DECISION DELEGATED TO HEAD OF PLANNING

Application No: H16-0662-26 **Applicant:** Stamford Properties Development Ltd

Proposal: Redevelopment, demolition and extension of vacant former Regent Bingo Club to include 41 residential units, comprising one, two and three bedroom apartments. The scheme also incorporates 298 sq m of flexible commercial floorspace within Use Class E (Commercial, Business & Service), together with dedicated residents external amenity space. The development will utilise existing vehicular and pedestrian access routes, providing parking areas to the rear with 28 parking bays and cycle parking, servicing arrangements and associated works.

Location: Former Regent Bingo Club Westlode Street Spalding

Ground Floor Plan
NTS

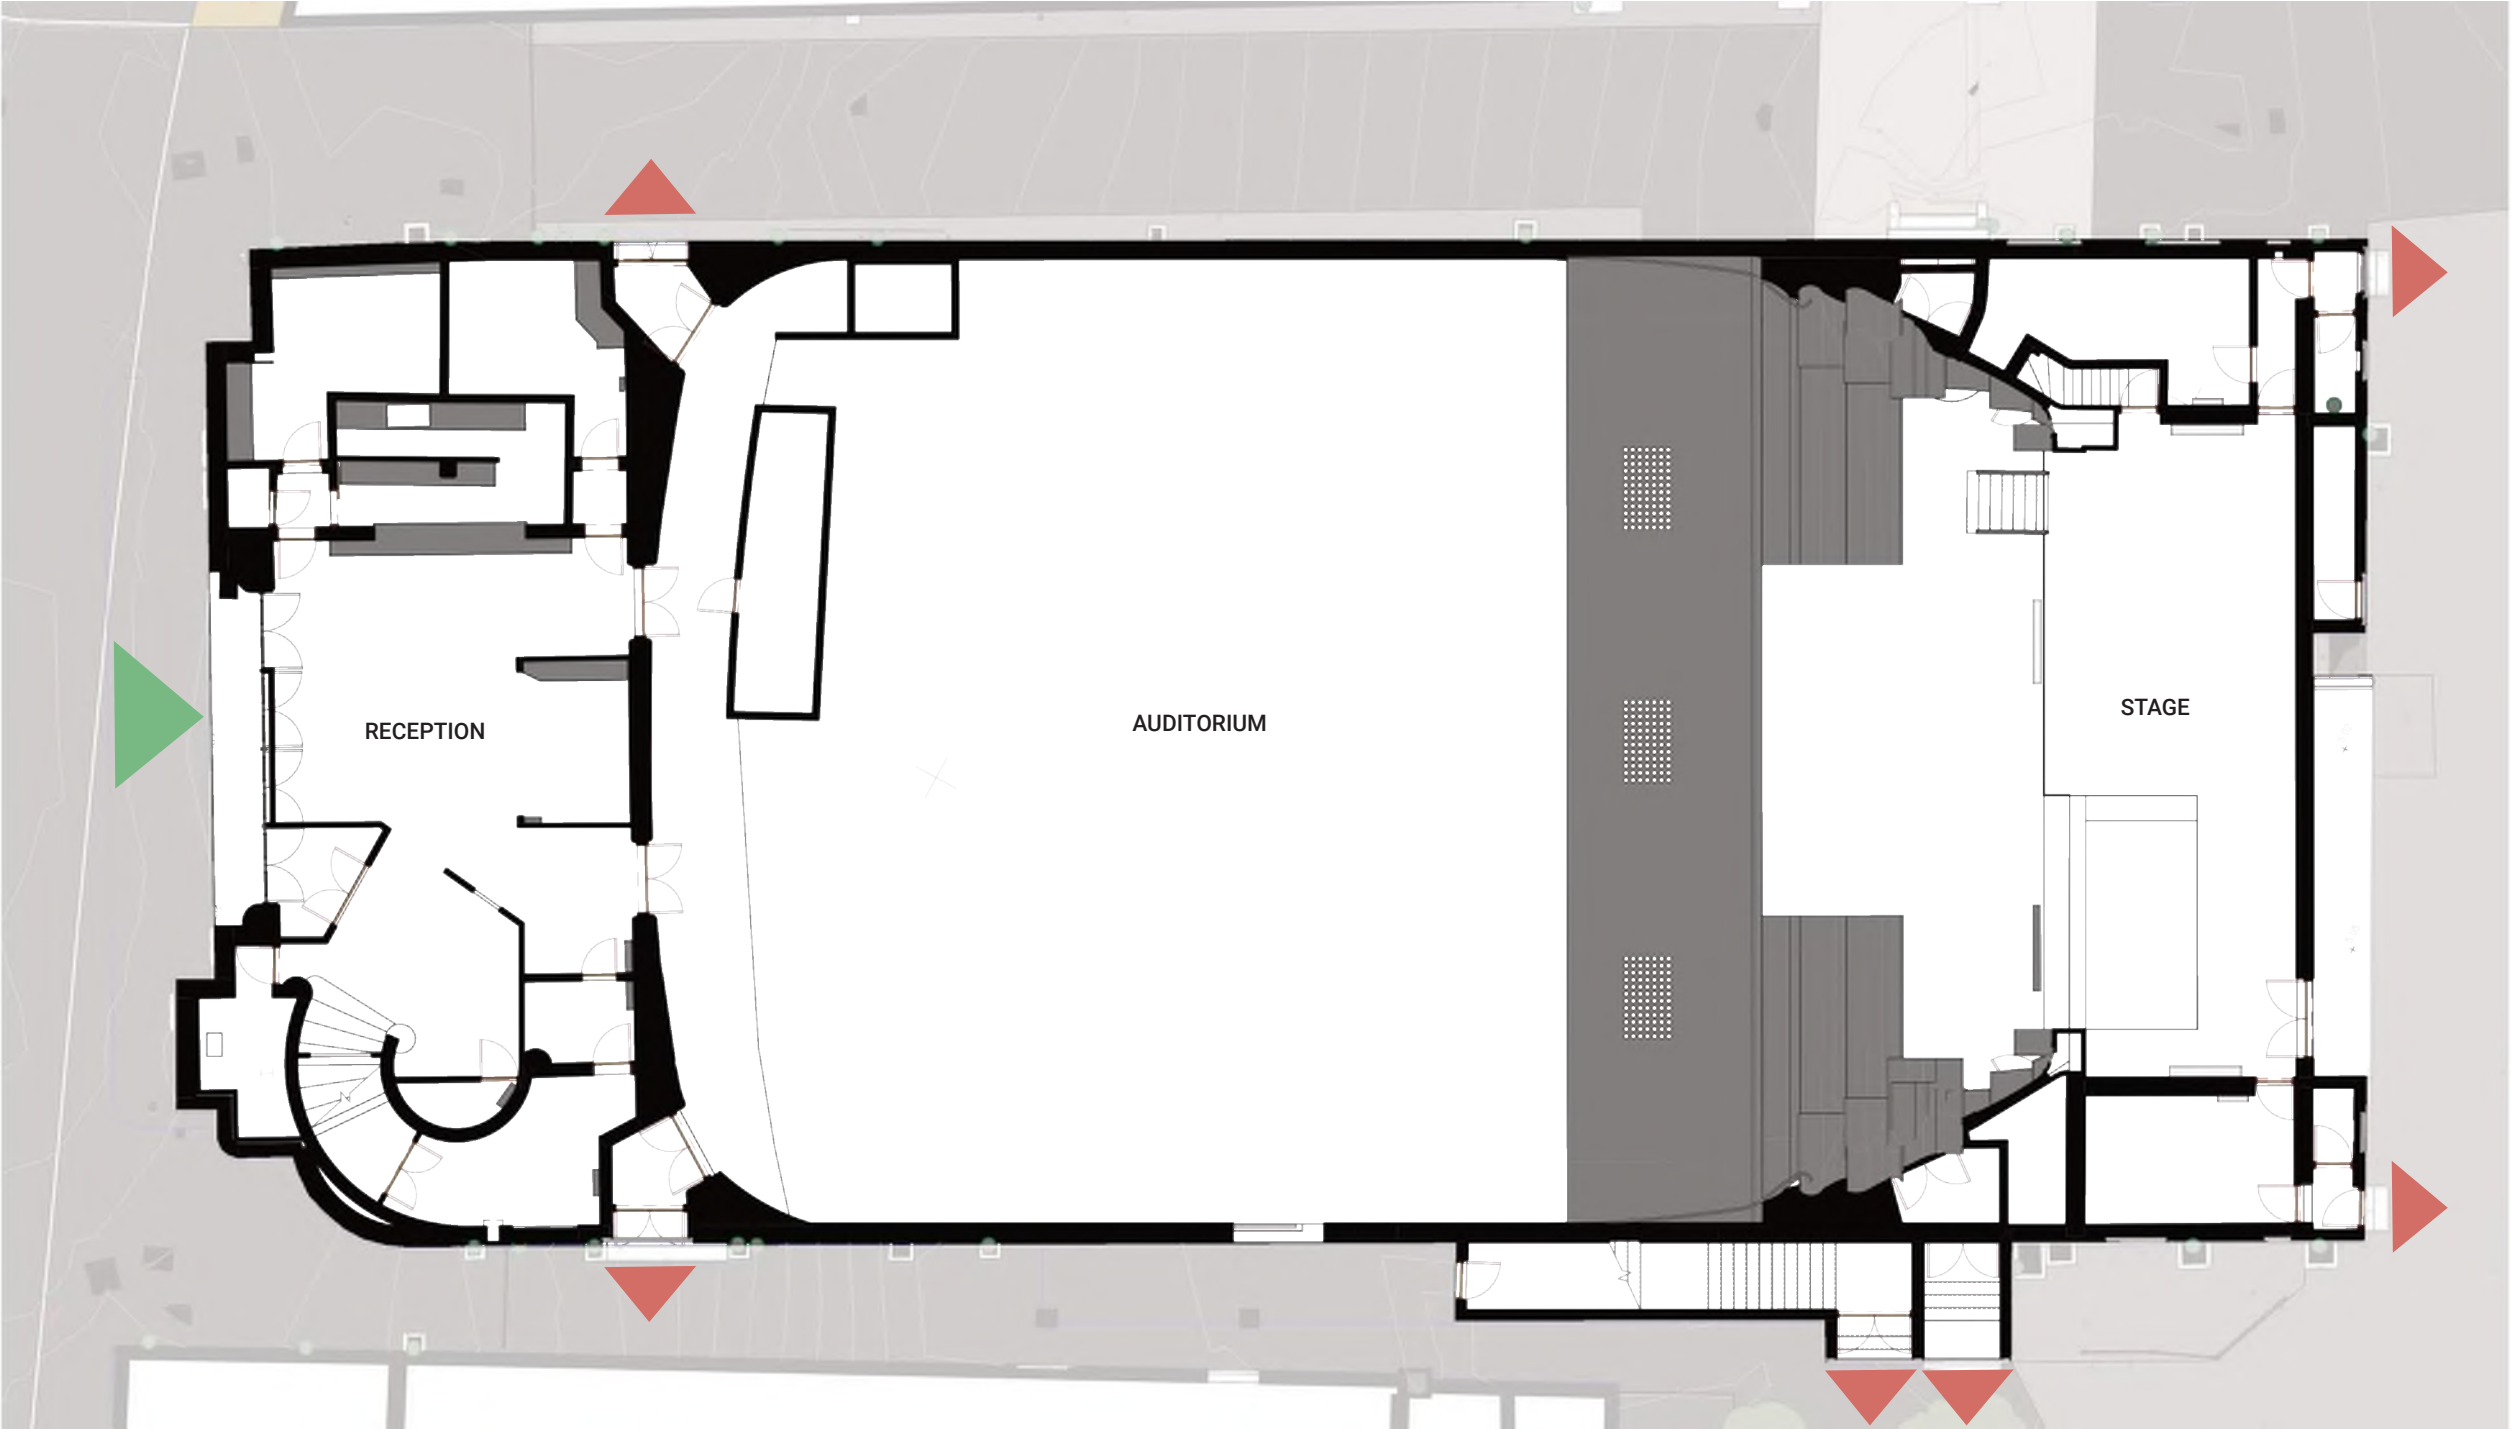
The proposal would provide 41 apartments and approximately 298 sq m of Class E commercial floorspace. The commercial accommodation would occupy the front of the building facing Westlode Street. The ground-floor plan shows 166.5 sq m labelled "Retail", with a direct entrance from the street. A further 131.6 sq m, also labelled "Retail", is shown at first-floor level, connected by the front internal staircase. Residential accommodation would be provided behind the commercial space and on the higher floors.

Although the plans label these areas as retail, the application form identifies Class E(b), covering the sale of food and drink mainly for consumption on the premises. The Design and Access Statement also identifies an opportunity for restaurant use. Both retail and restaurant uses would be appropriate town centre activities.

First Floor Plan
NTS

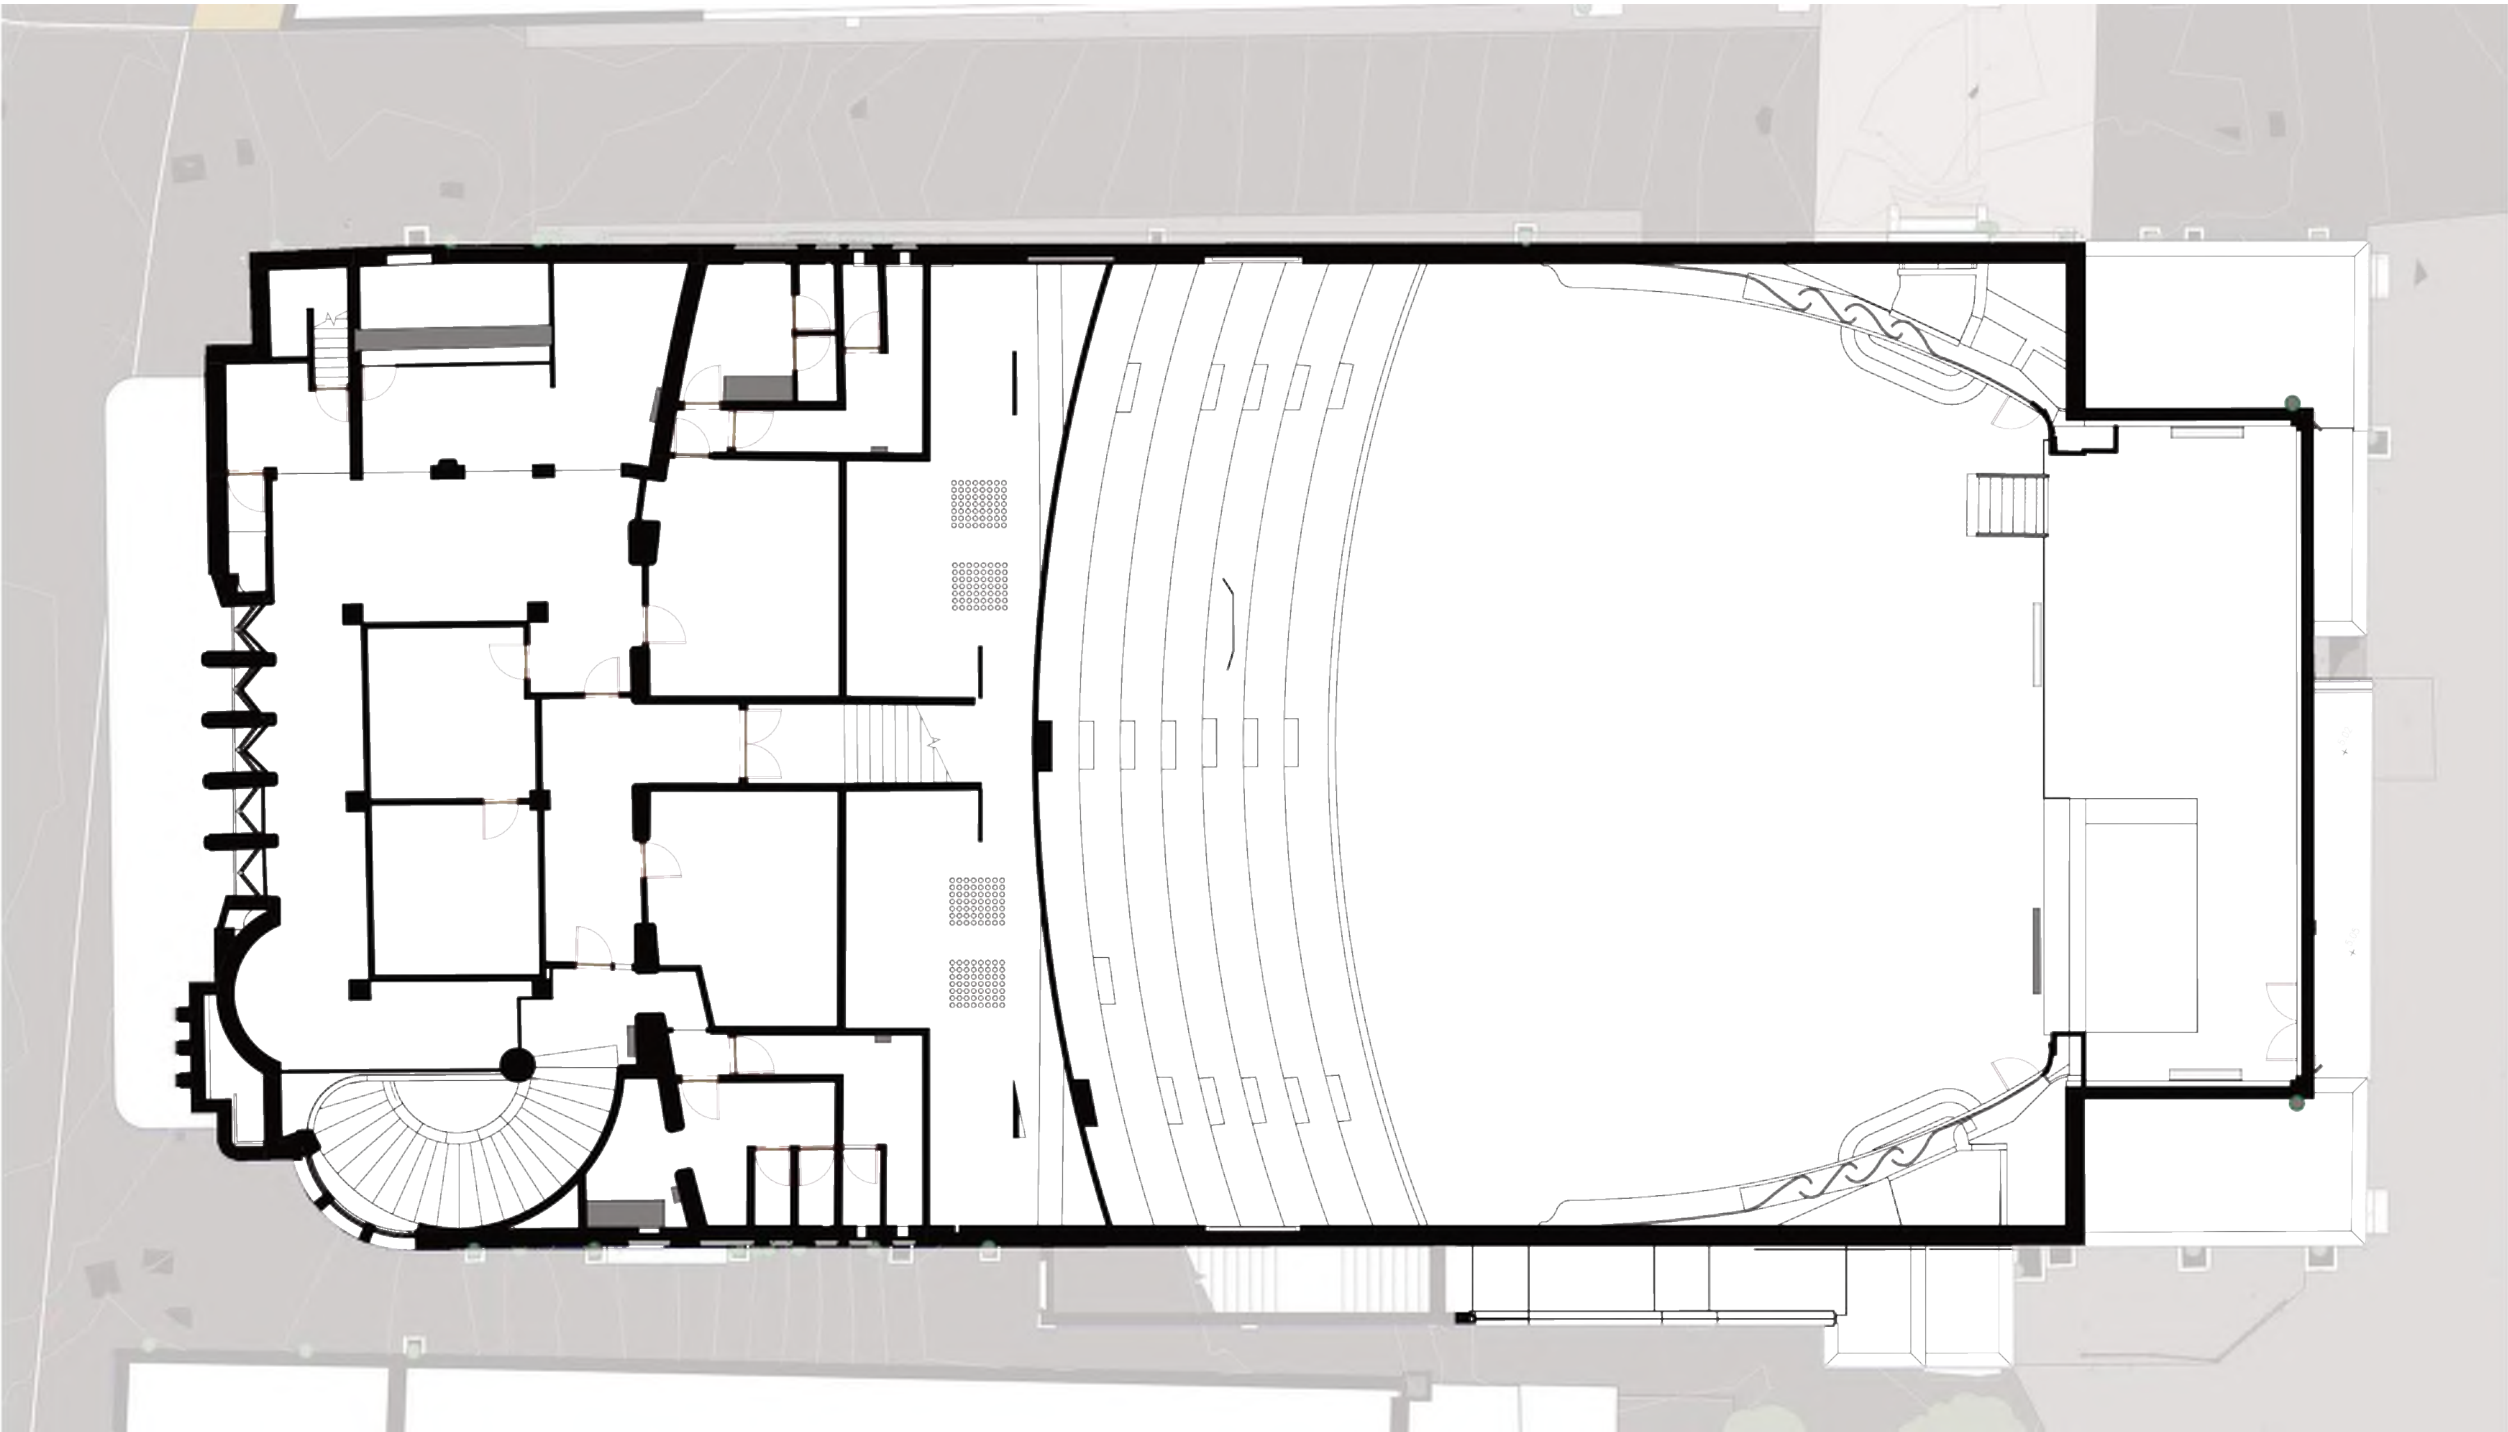
The first-floor accommodation is of particular concern because commercial activity would take place alongside residential accommodation at the same level.

The proposed Class E use could include a restaurant. This could generate noise from customers, music, kitchen equipment, extraction systems, deliveries and refuse handling, together with cooking odours. Noise could pass through the building as well as affect residents through their windows and when using the communal terrace.
